25 November 2013

MP09_0088 (MOD9) – THOMAS STREET CAR PARK SITE CHATSWOOD

I refer to Willoughby City Council's letter of the 13 November 2013 and submissions received for amendments to the basement levels and provide a response to the issues below.

1 GROUND FLOOR PLAN
1:200

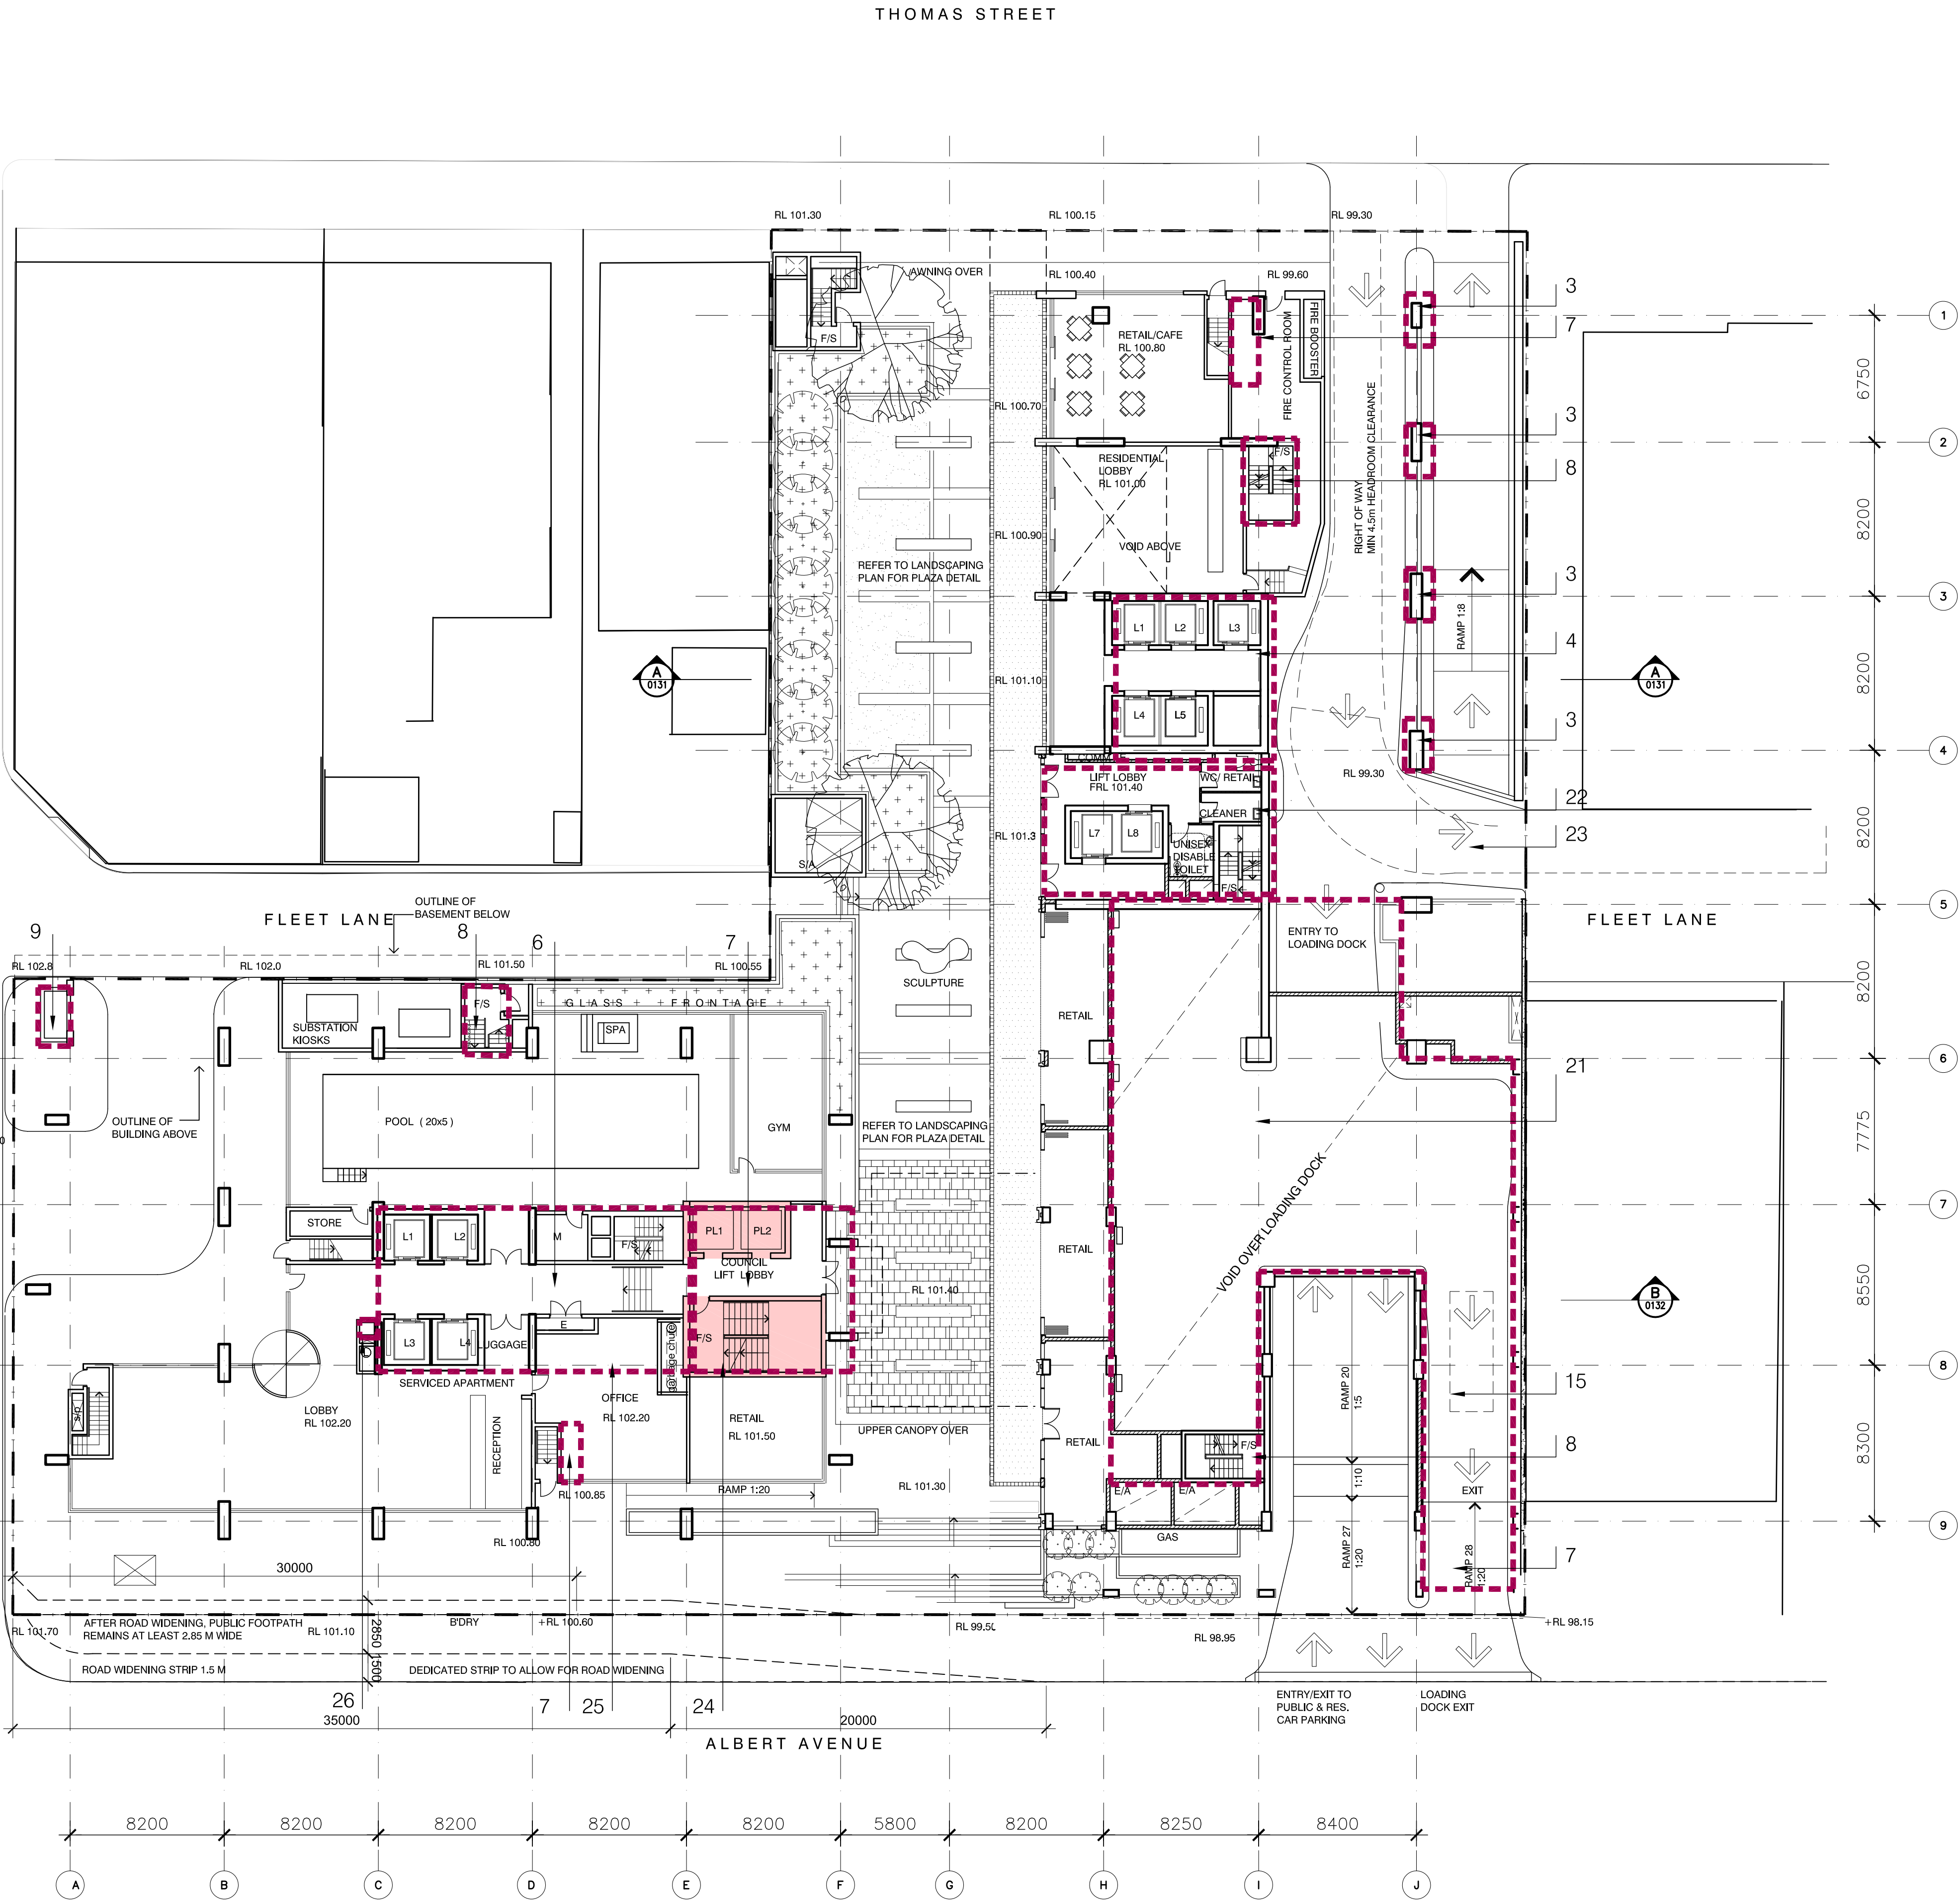
3. Separation of the car park entry and exit lanes to Albert Avenue was to be provided and is not shown. Such separation is not to extend such that it obstructs the public footpath.

6. Only a 3 metre wide entry is provided to the car park such that left in left out only must operate in Albert Avenue. A median is required in Albert Avenue to stop the right turn movement into the car park.

7. To ensure a vehicle can enter the car park from the left lane in Albert Avenue, the crossing of the footpath requires a splay widening of 1.8 metres. It is noted that the footpath is to be a consistent grade for pedestrians in accordance with Council's requirements in the Chatswood CBD.

12. The pedestrian crossing in the right of way shall be designed to provide for people with disabilities.

Response – This is now shown on the plans as Point 3 in **Annexure 1**.

Response – A median strip along Albert Avenue is now shown on the amended plans to stop the right turn movement into the car park. Refer to **Annexure 1**.

Response – Compliance with this requirement is shown on the plans in **Annexure 1**.

Response – The plans show the reinstatement of the pedestrian crossing for people with a disability that was previously proposed in Modification 6. – refer to **Annexure 1**.

A-0110 G
CONSTRUCTION CERTIFICATE

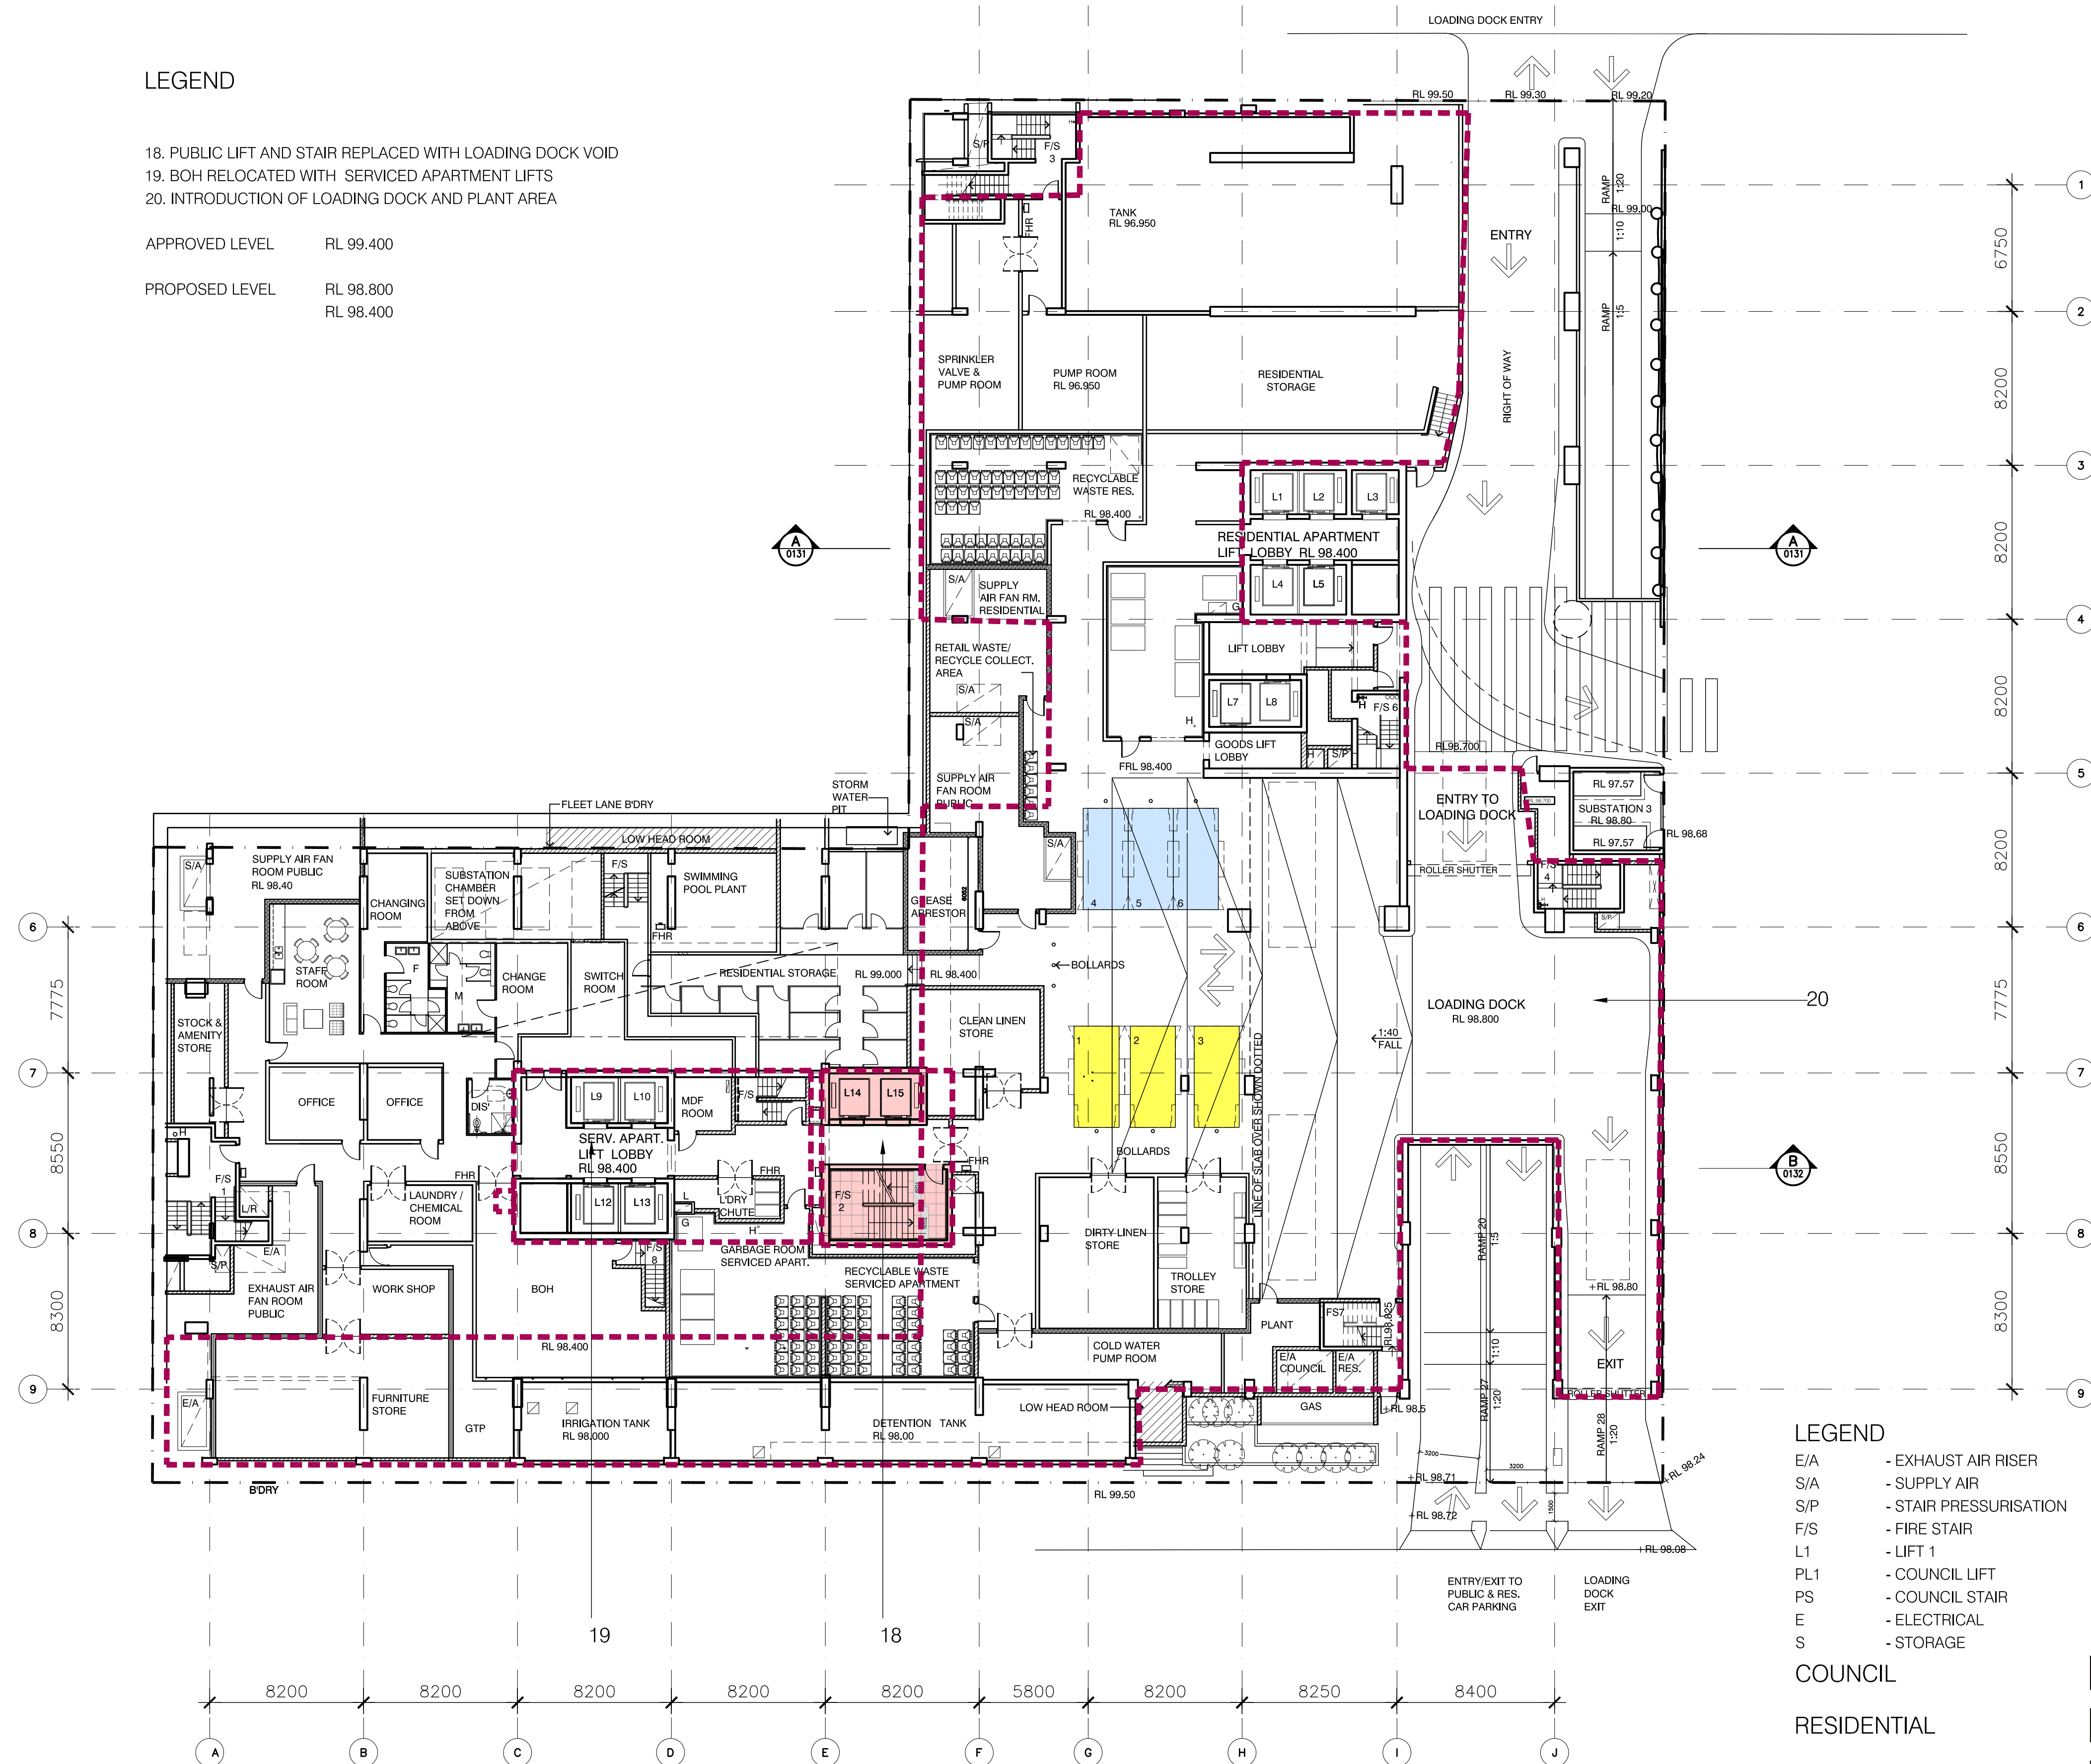
9. An access capable of being locked when not in use from at least one of the public car park lifts is to be provided to the mezzanine level for access to the loading dock.

Response – No objection is raised to this request and is difficult to identify on architectural plans. This request can occur to lift L15 and a suitable condition be put in place as outlined below.
